Your ref: SSD 17352813  
File no: MC-21-00001

**SSD 17352813– Huntingwood Processing Facility Expansion – 65  
Huntingwood Drive, Huntingwood**

# **Blacktown Council's submission to SSD 17352813 – Huntingwood Processing Facility Expansion**

## **1. Drainage Engineering Issues**

DA4301

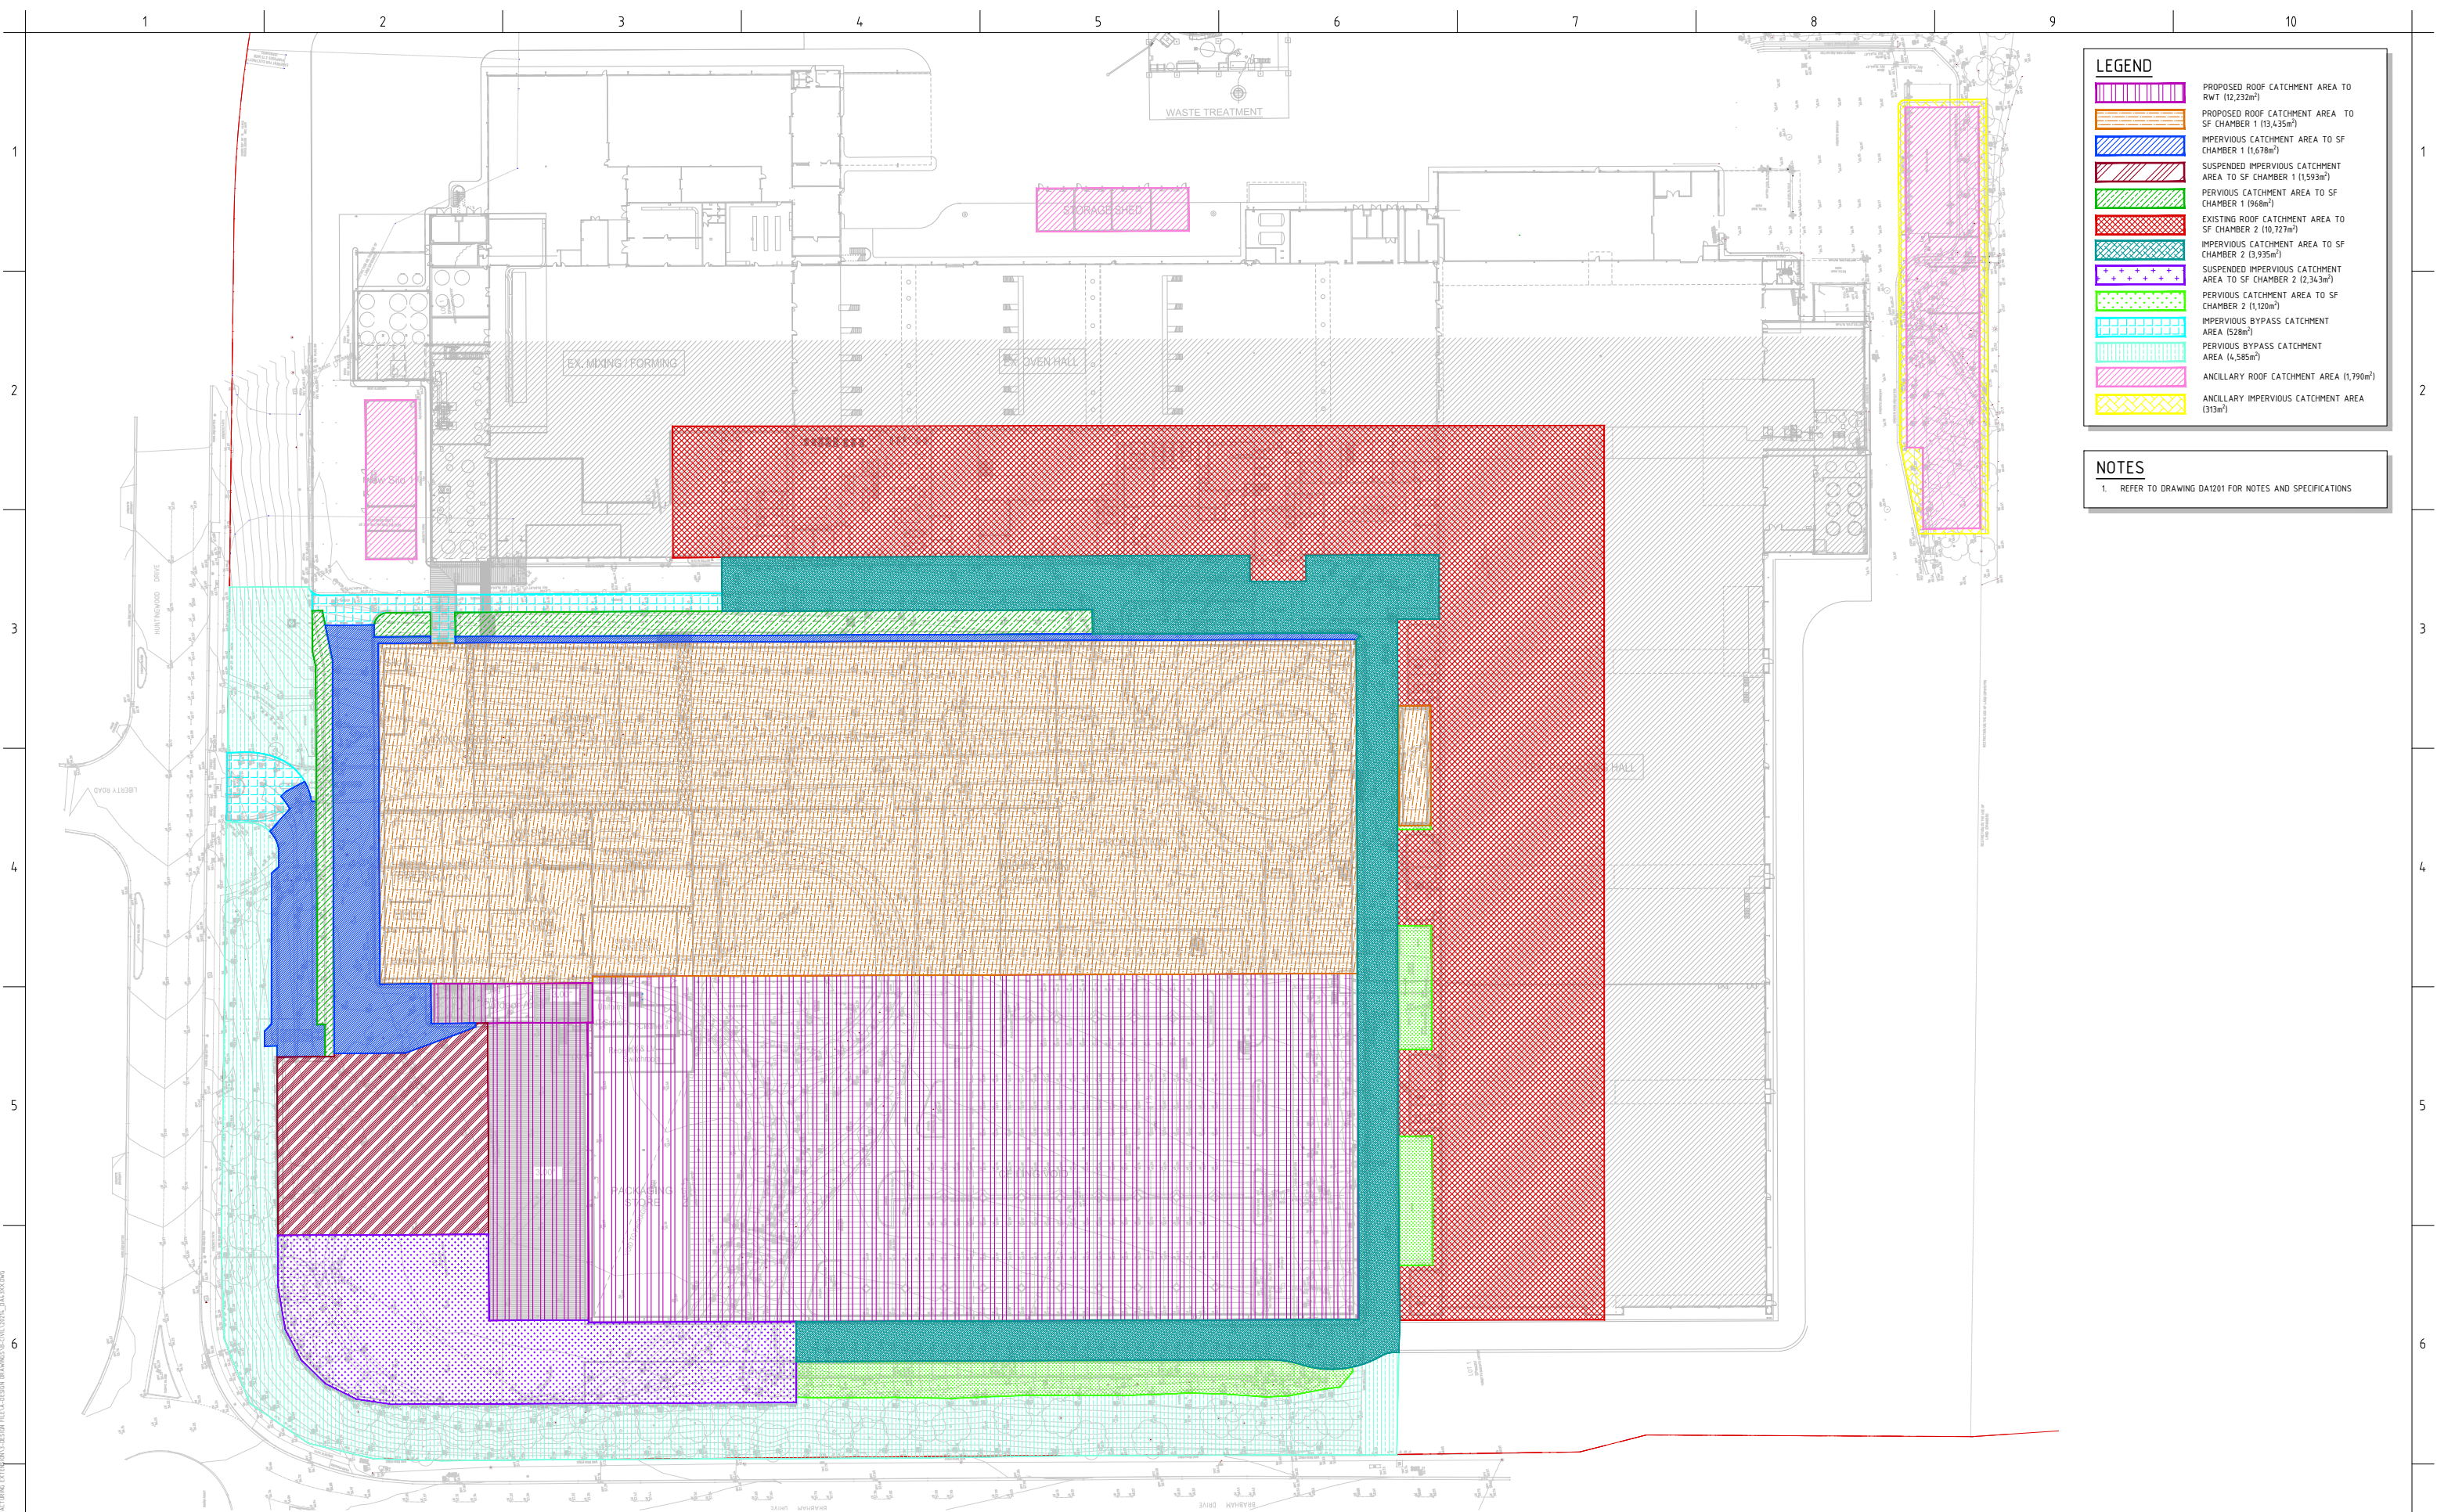
- b. It appears that on Dwg. DA4301 ancillary catchment (1790 + 313m2) are unaccounted for. These are to be either treated or considered as bypass for Water Quality. Confirm water quality approach regarding the ancillary catchment (1790 + 313m2) as shown on Dwg. DA4301.

- d. Ensure Model for Urban Stormwater Improvement Conceptualisation model matches the plans in terms of names, abbreviations, areas and land use.
- e. Label each sub-catchment on Dwg. DA4301 i.e. on top of the hatchings for ease of identification.
